KOORAGANG ISLAND

RE: Orica Kooragang Island Expansion Project (08_129): MOD 5: Stack Height

Attachment A – ANP1 Prill Tower Emissions Abatement Irrigated Fibre Bed Scrubber - General Arrangement Drawing and Side View (as file "C7711-000-ME-GA-00-0004_rA.pdf")

PROJECT ANP1 PRILL TOWER EMISSIONS ABATEMENT IRRIGATED FIBER BED SCRUBBER
TITLE OVERALL PLANT LAYOUT
DRG NO. C7711-000-OV-SK-00-0001
SHEET 1 of 1
REV A

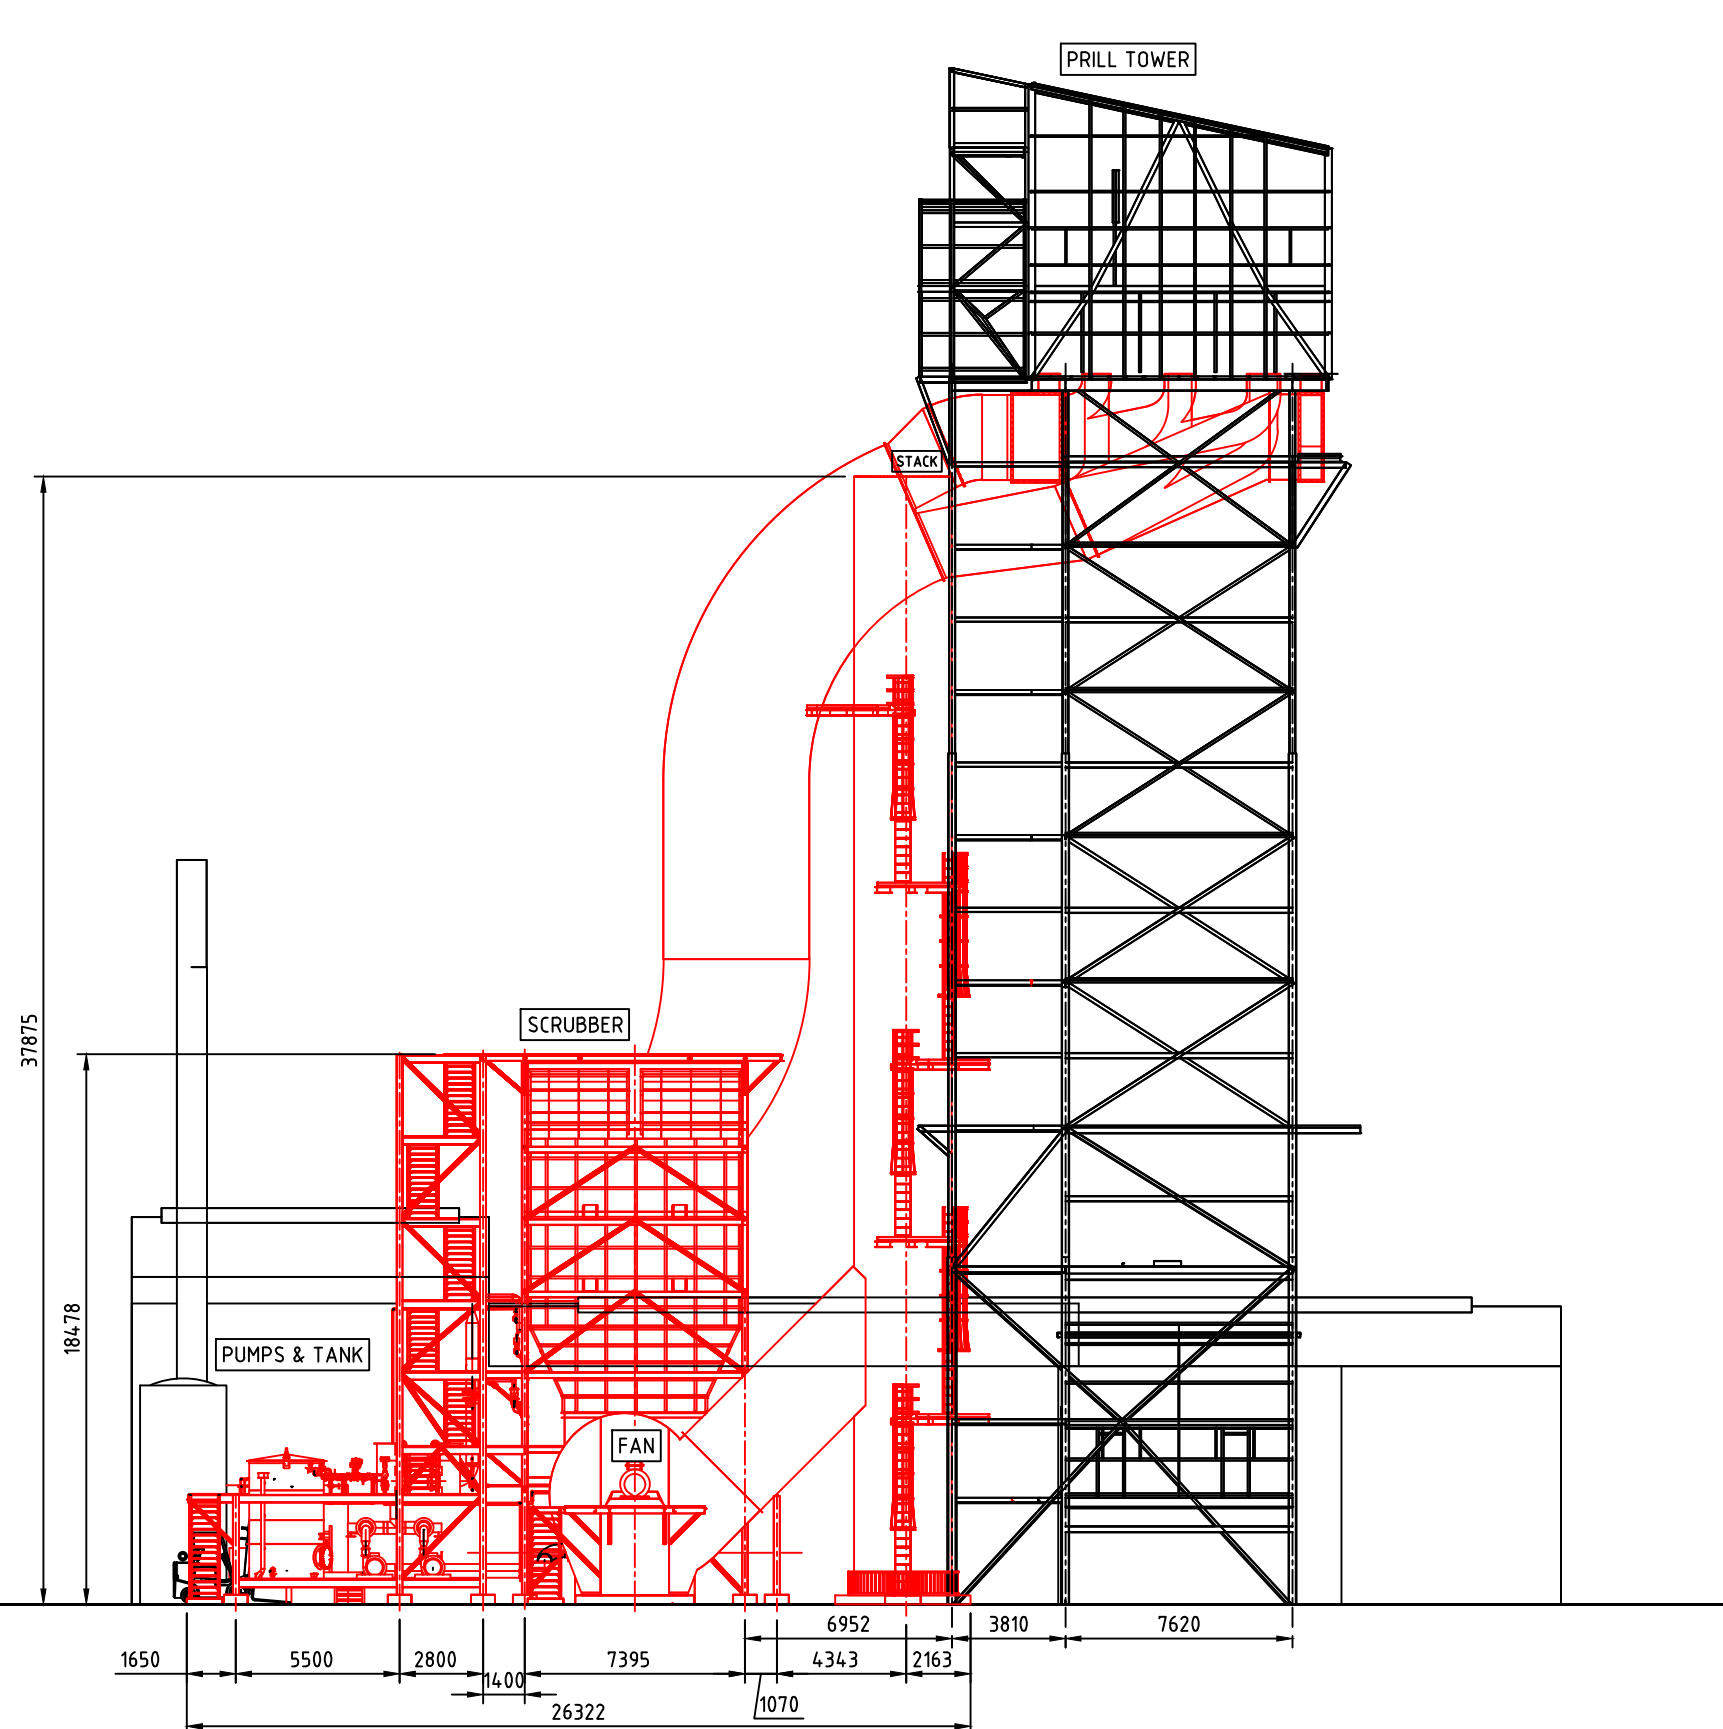
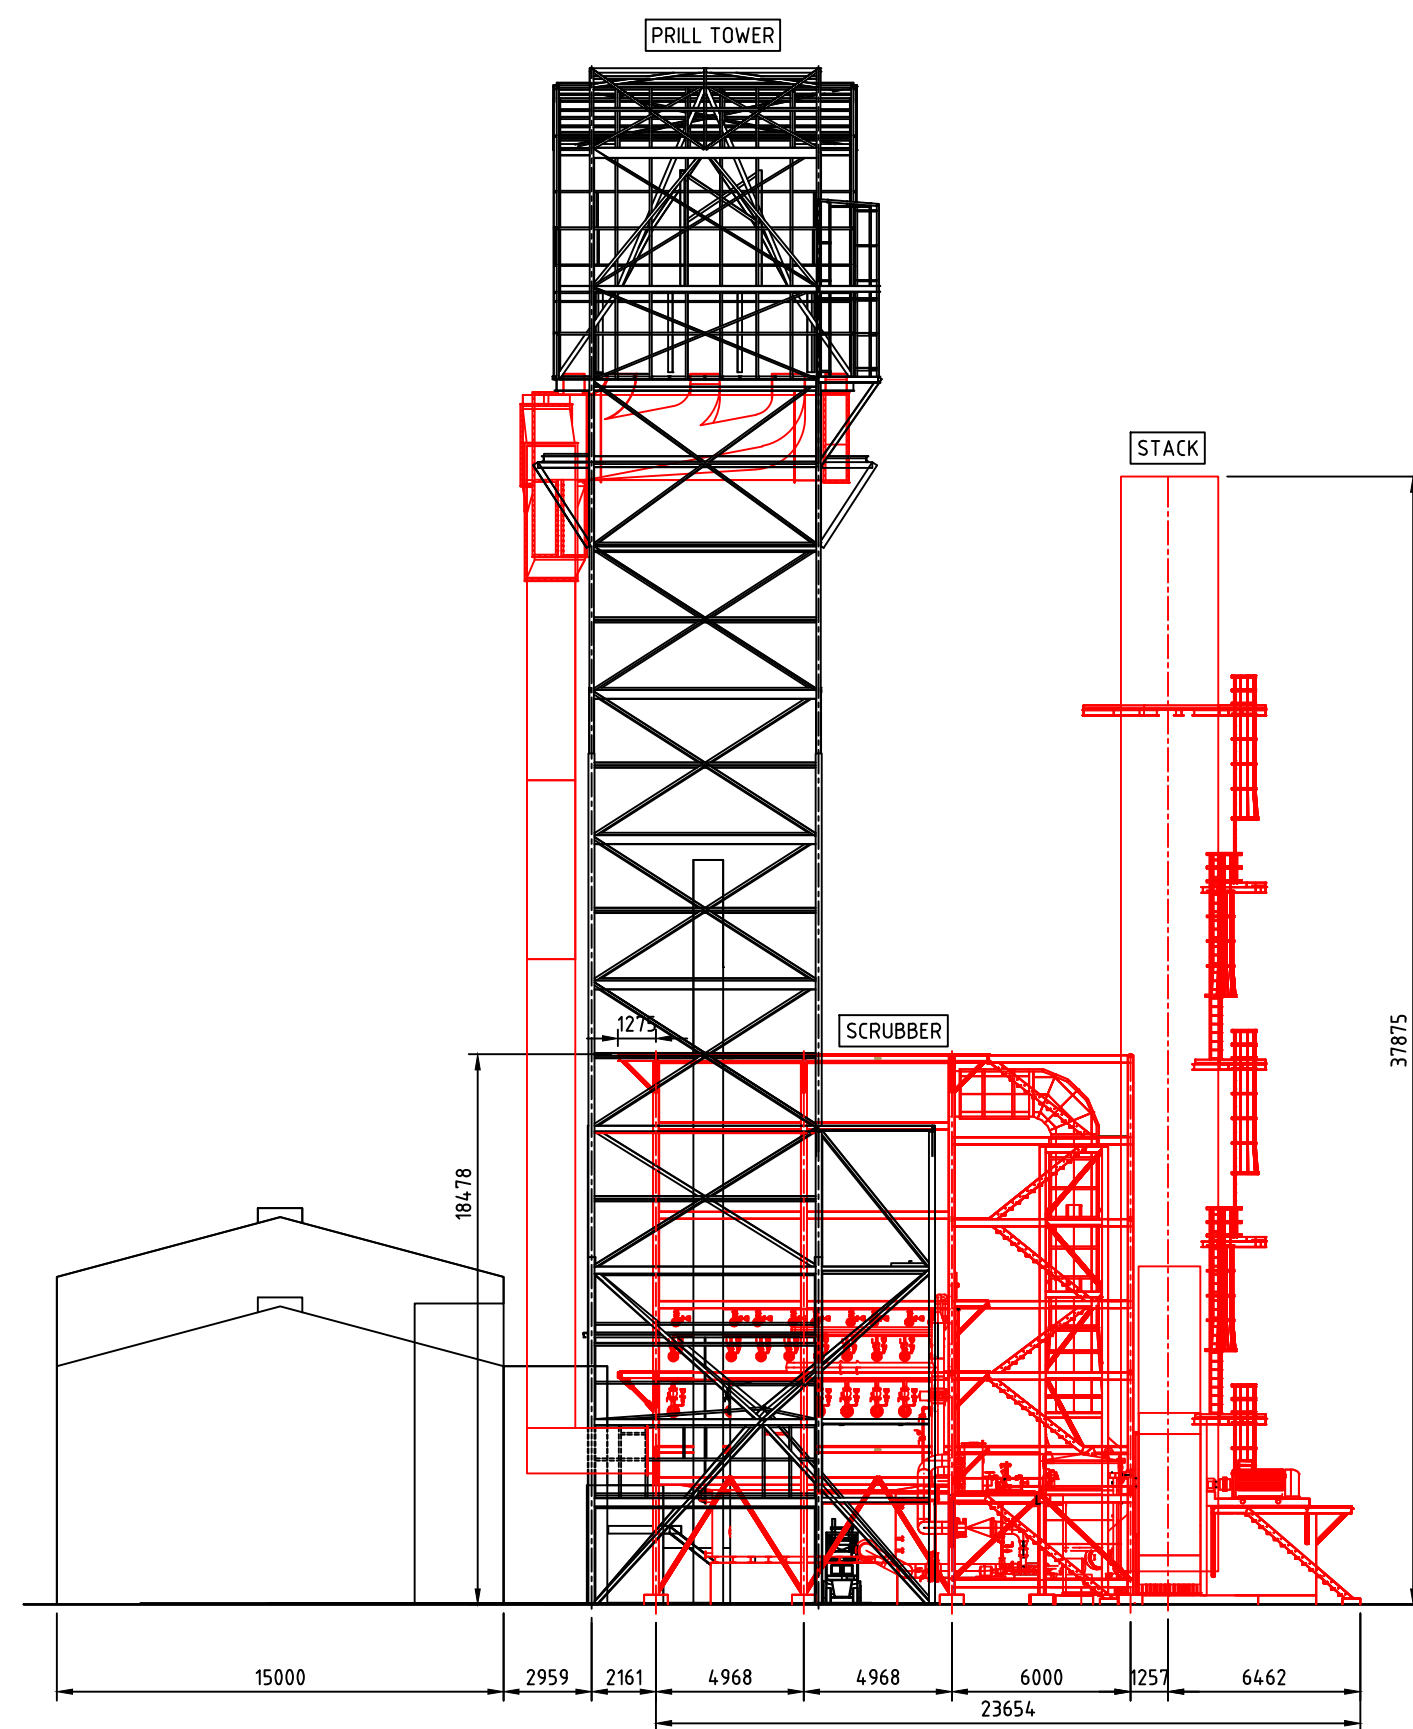
As discussed, Orica KI confirm that the proposed stack height for the Prill Tower Scrubber Project (08_0129 MOD5) is 37.5m. The AQIA modelling calculation included in the Environmental Assessment was based on a 37.5m high emission point, but due to differences in drawing dimensions during preparation of the AQIA a drawing showing the stack height a 37.9m was included in the text of the report.

Please find attached the latest general arrangement drawing showing the stack height as 37.5m. As noted previously, "for construction" drawings have not been prepared at this stage of project development, but any changes from this point are likely to be minor engineering changes to improve constructability or maintainability.
